Ribble Valley Borough Council
Housing & Development Control

Application no: **3/2024/0134**

Address: **Black Bull Inn Old Langho Road Old Langho BB6 8AW**

Proposal: **Proposed change of use of adjacent agricultural field to car park and change of use of existing rooms to three guest bedrooms.**

A1.2

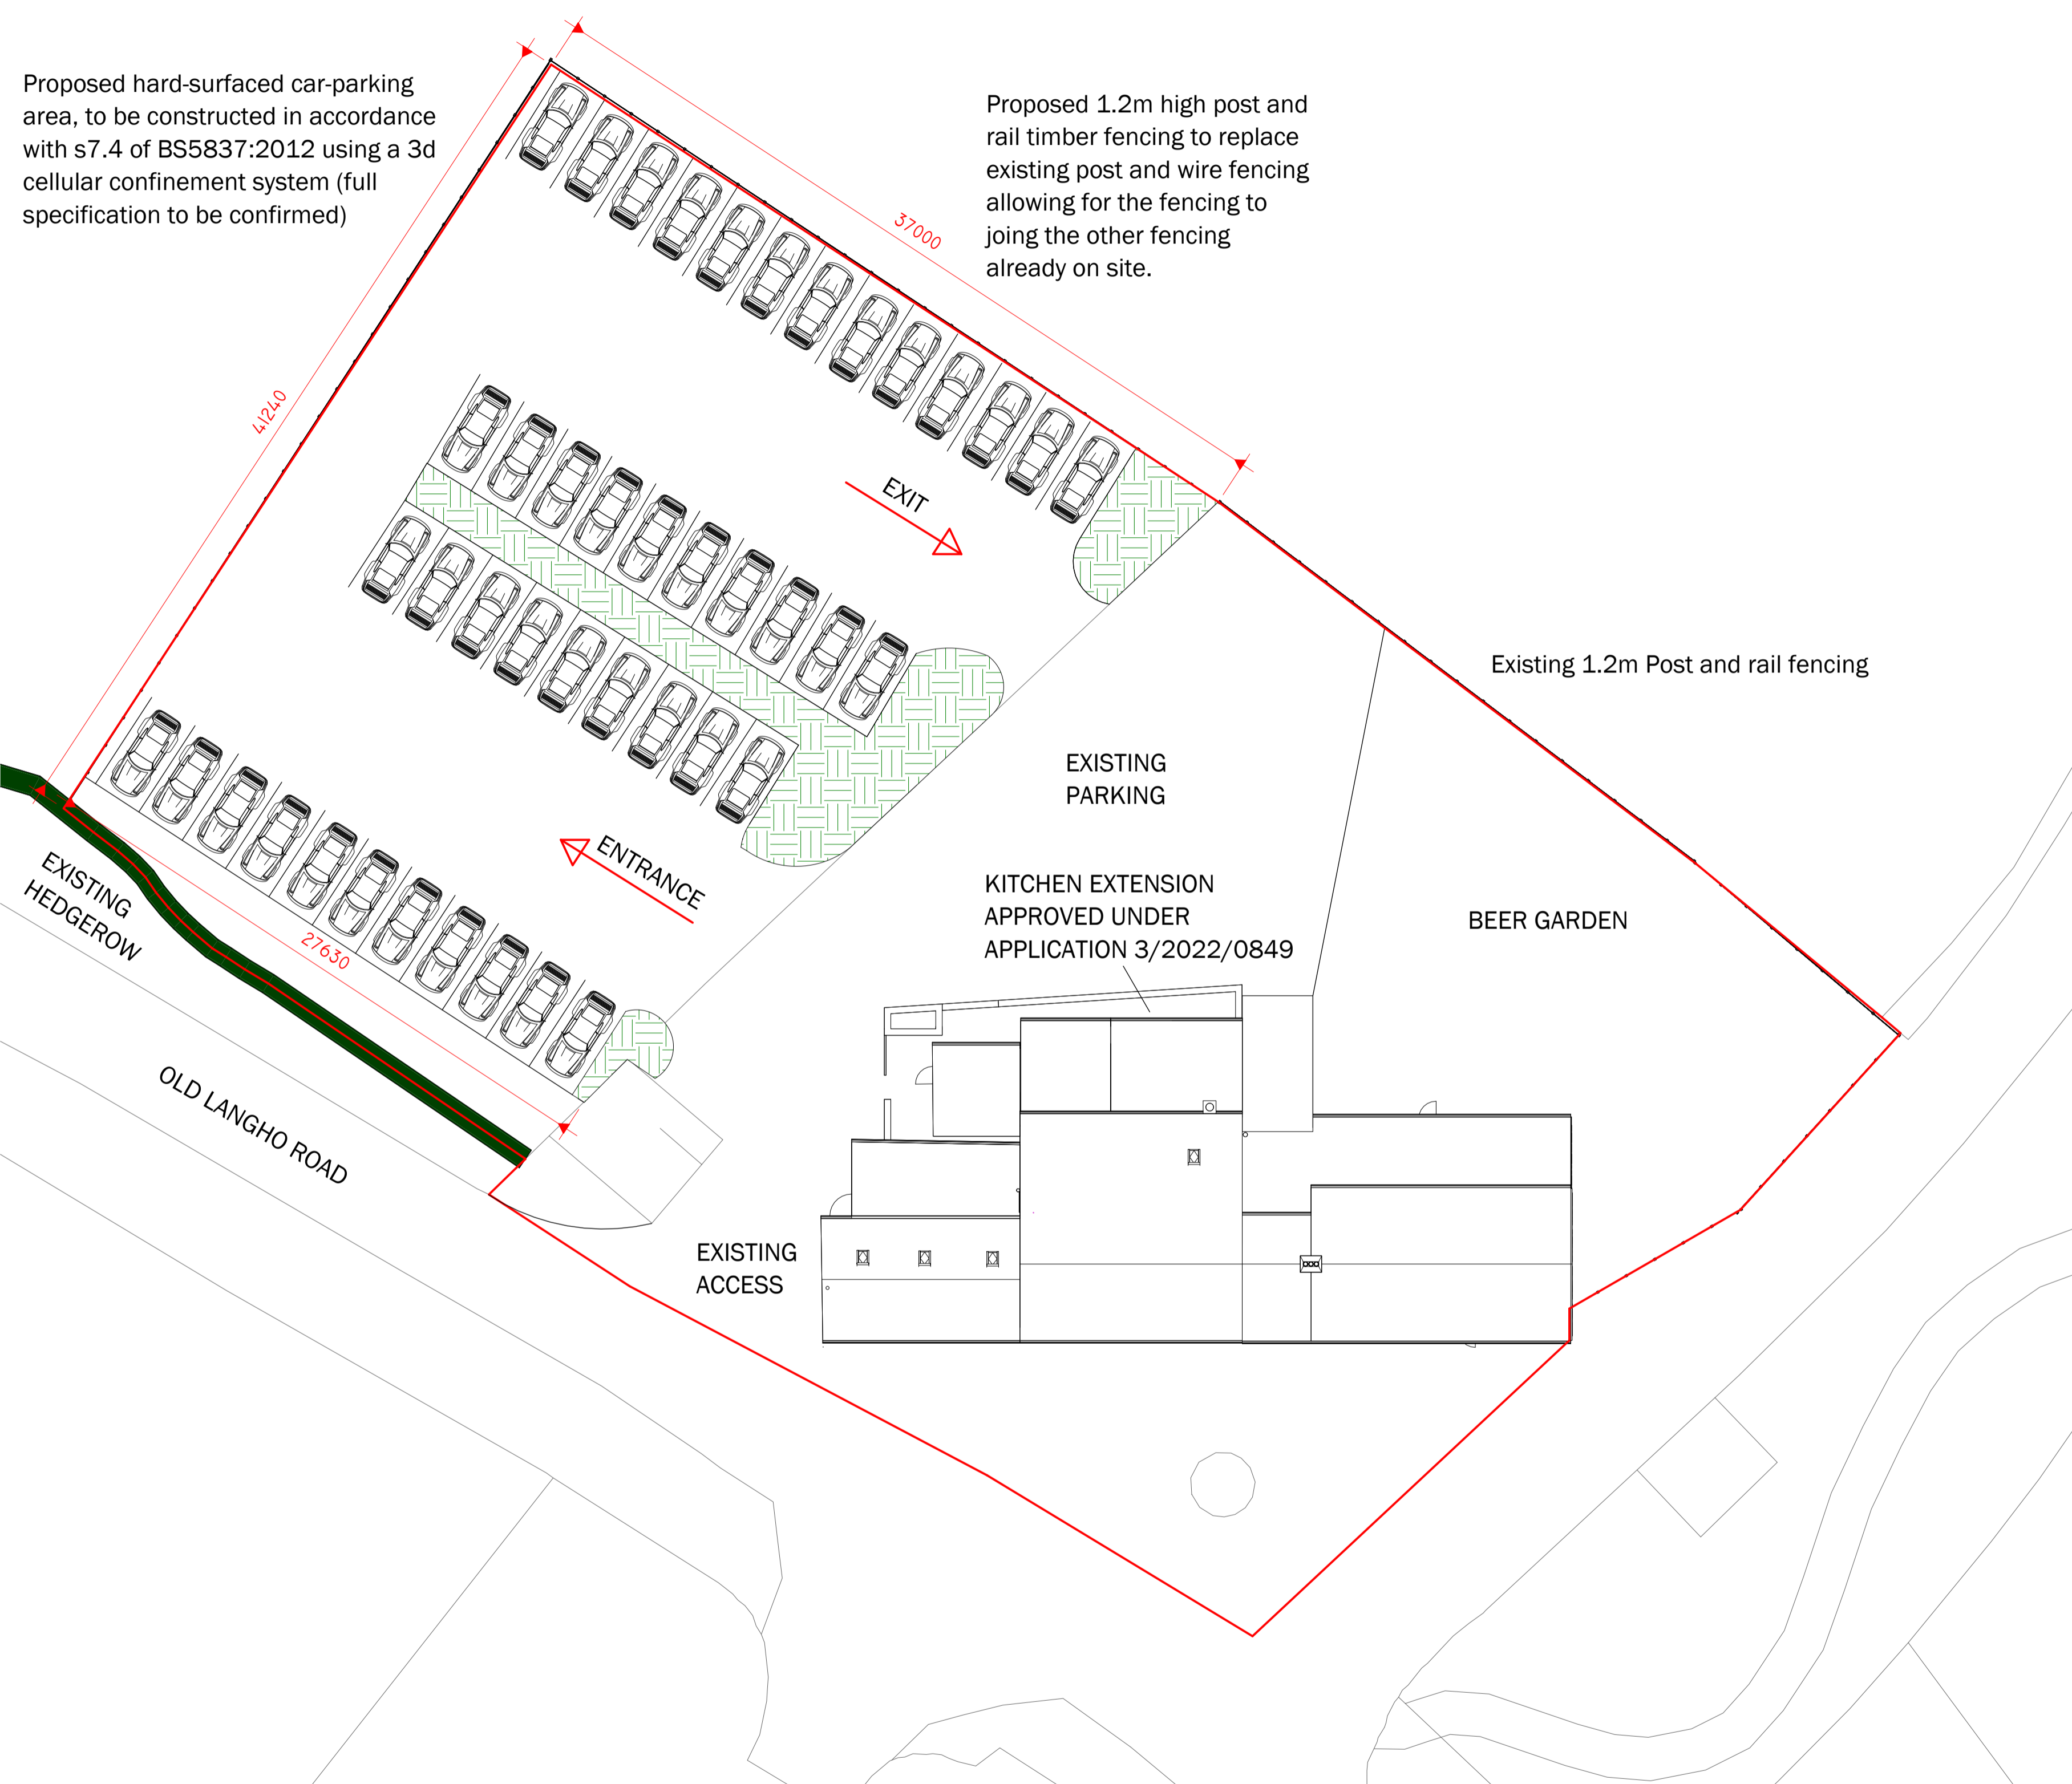
The LHA have reviewed Peter Hitchen drawing number A1.2 titled "Proposed Site Plan" and welcome the extension to the car park which will create an additional 43 car parking spaces. Given that the extension to the car park will continue to use the existing site access which already serves the existing car parking area, the LHA have no objection to the change of the use of the adjacent agricultural field.

The LHA also have no objection to the provision of three guest bedrooms at the site following the conversion of the first floor. This is because following the extension to the car park, there will be adequate space for guests to park.

1. The development hereby permitted shall not be occupied until such time as the parking and turning facilities have been implemented in accordance with Peter Hitchen drawing number A1.2. Thereafter the onsite parking provision shall be so maintained in perpetuity.
